Response to P/132/20/RES – Land North of Hook Lane, Pagham – approval of reserved matters following P/30/19/OUT for 300no new homes, internal roads, footpaths & cycleways, car parking & landscaping. This application affects the setting of a listed building & falls within Strategic site H SP2, CIL Zone 1 (Zero Rated). Comments re: amendments dated 28th May 2021.

RESPONSE TO P/79/21/RES Land North of Hook Lane, Pagham – approval of reserved matters following P/30/19/OUT for 300no new homes, internal roads, footpaths & cycleways, car parking & landscaping (resubmission of P/132/20/RES). This application affects the setting of a listed building & falls within Strategic site H SP2, CIL Zone 1 (Zero Rated).

Project **Hook Lane, Pagham**  
Drawing **Refuse Strategy Layout**

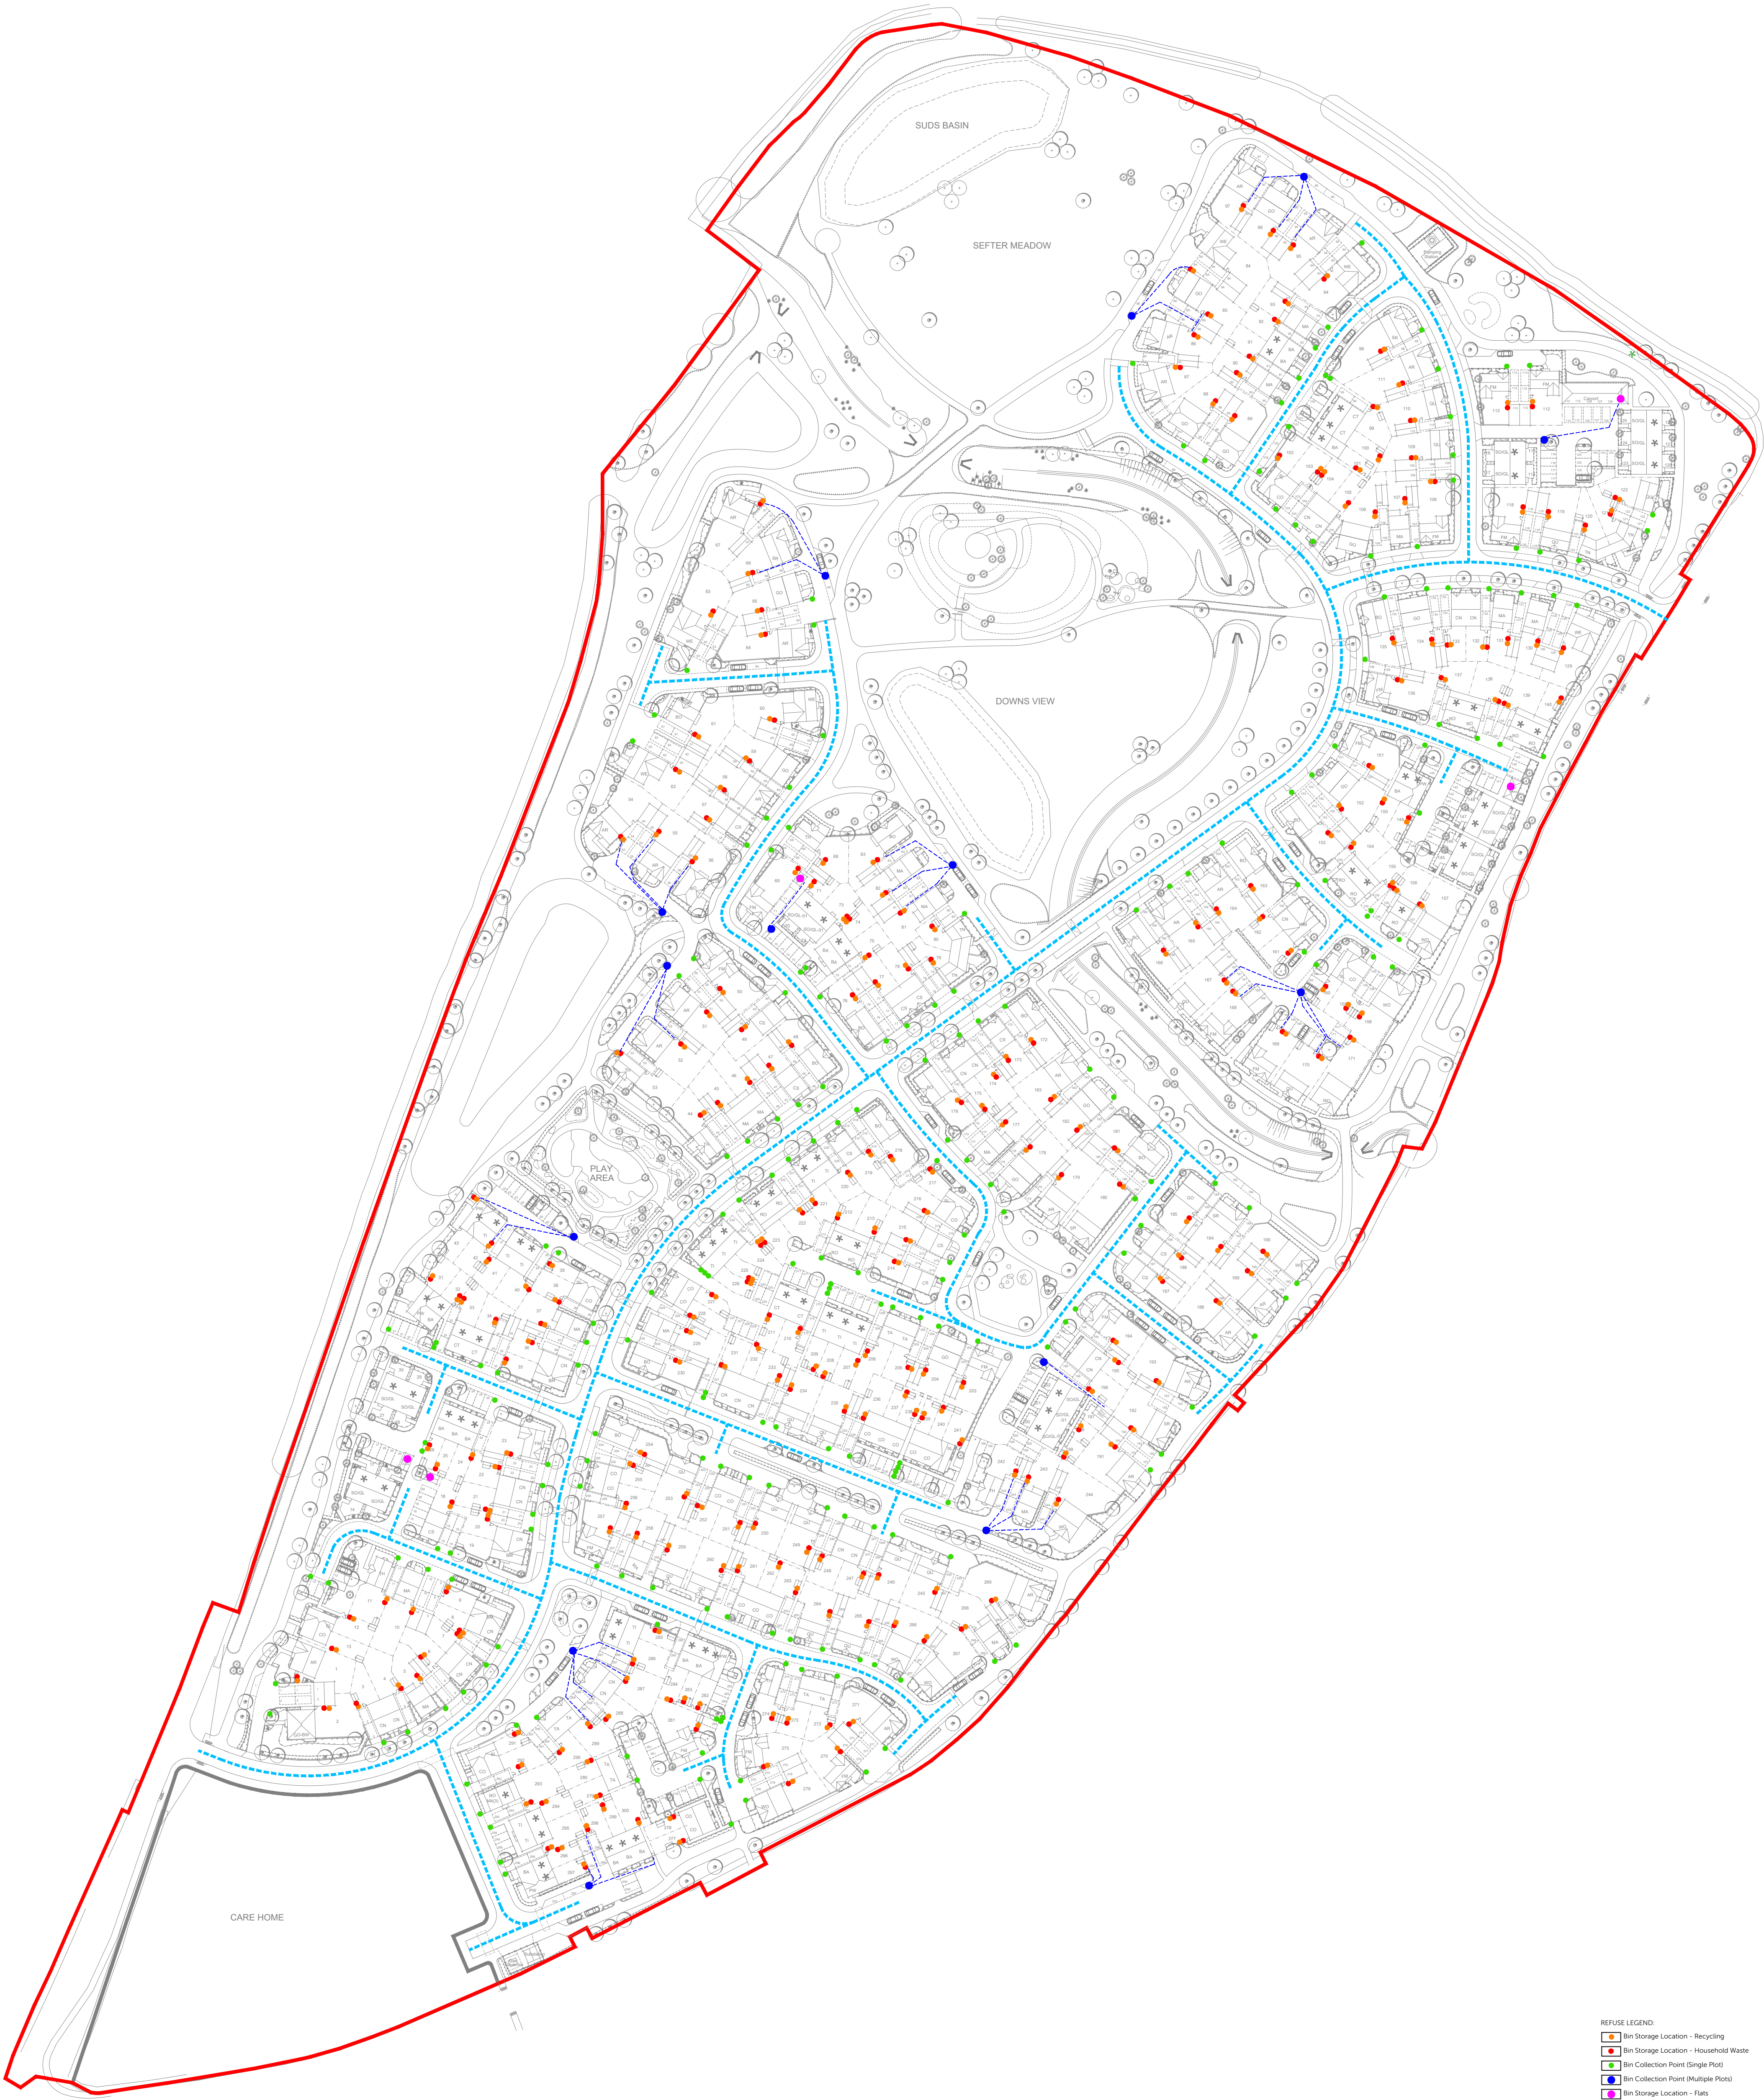
Furthermore, we note the use of the phrase “incredibly tight” in relation to refuse vehicle turning at certain plots. We support the request to ask ADC refuse department for comment.

Given the comments made in relation to potential problems with refuse vehicles turning, we suggest ADC refuse department are consulted on this application.

Project **Hook Lane, Pagham**
Drawing **Site Layout**

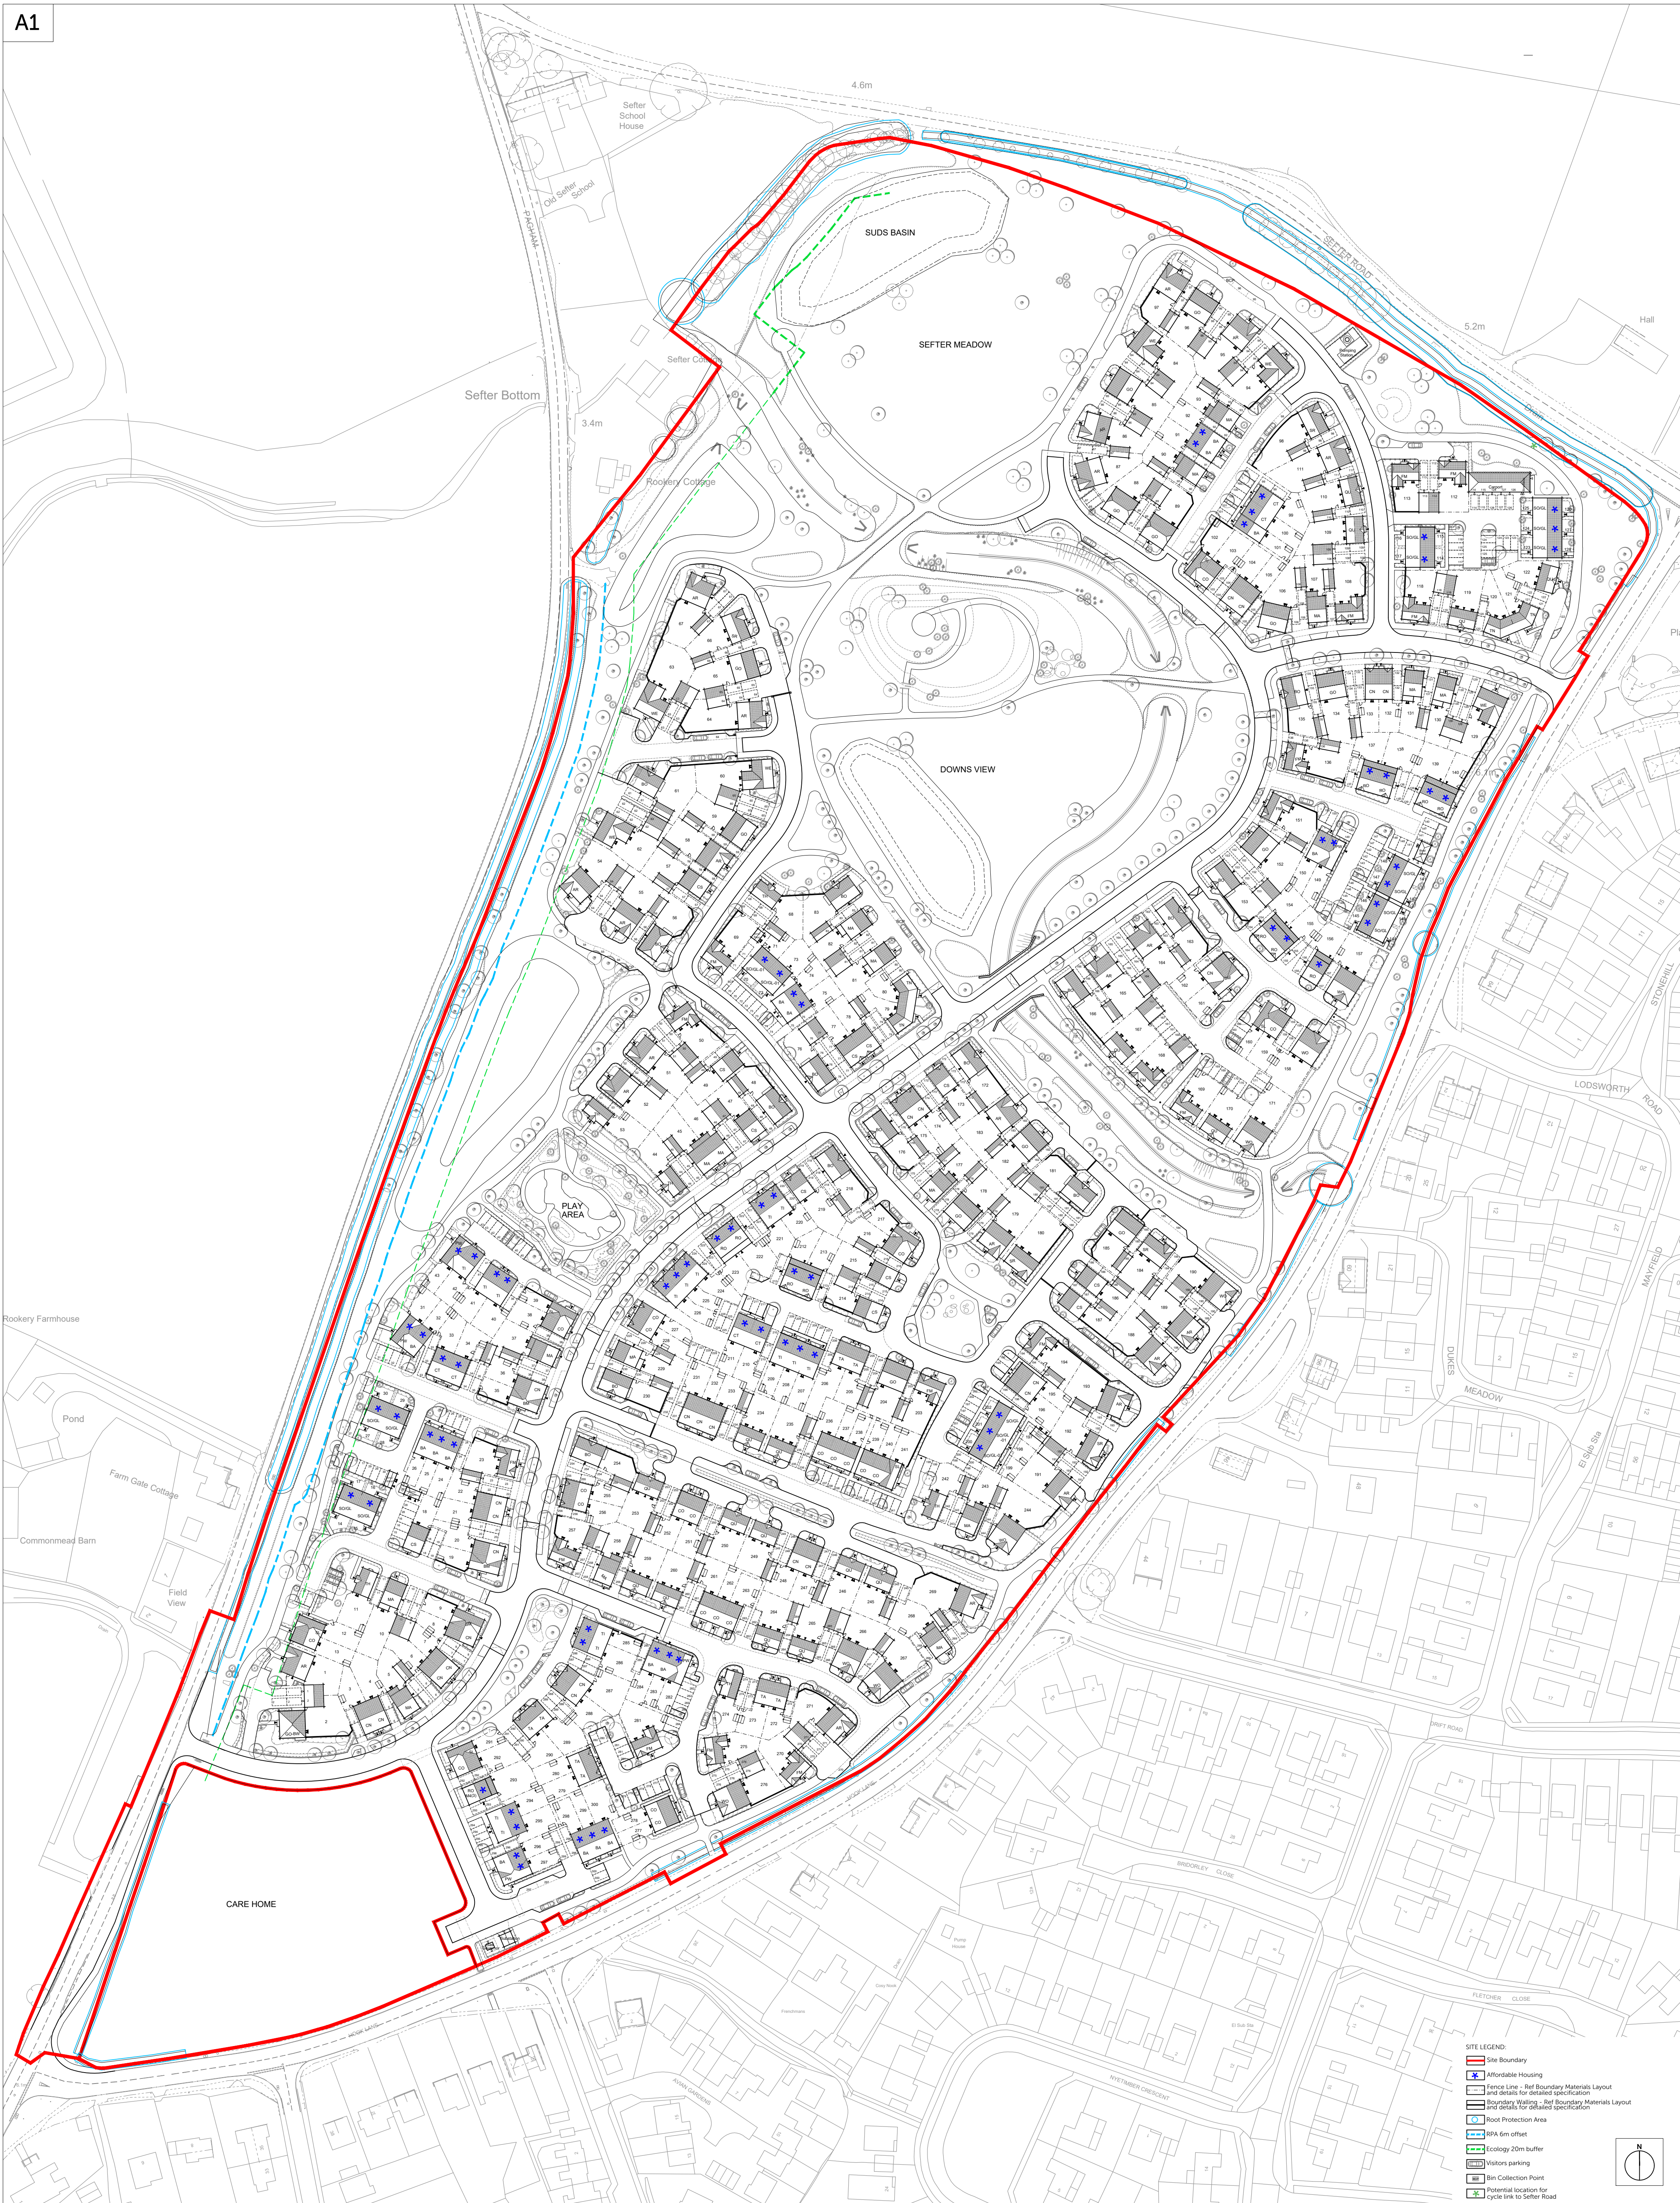
Regarding the amendments made, the Parish Council notes the comments of the West Sussex County Council Highways officer. It is disappointing to see the issues raised previously, which were supported by the Parish Council, have not been addressed. We remain concerned about the width of the roads and the prospect of parking on the roadside preventing access by emergency and refuse vehicles.

supported by the Parish Council, have not been addressed. We remain concerned about the width of the roads and the prospect of parking on the roadside preventing access by emergency and refuse vehicles.

Concerns over the width of the roads – they are narrower than the Council would like to see. The issue can be that emergency services vehicles will not be able to navigate the road sufficiently quickly.
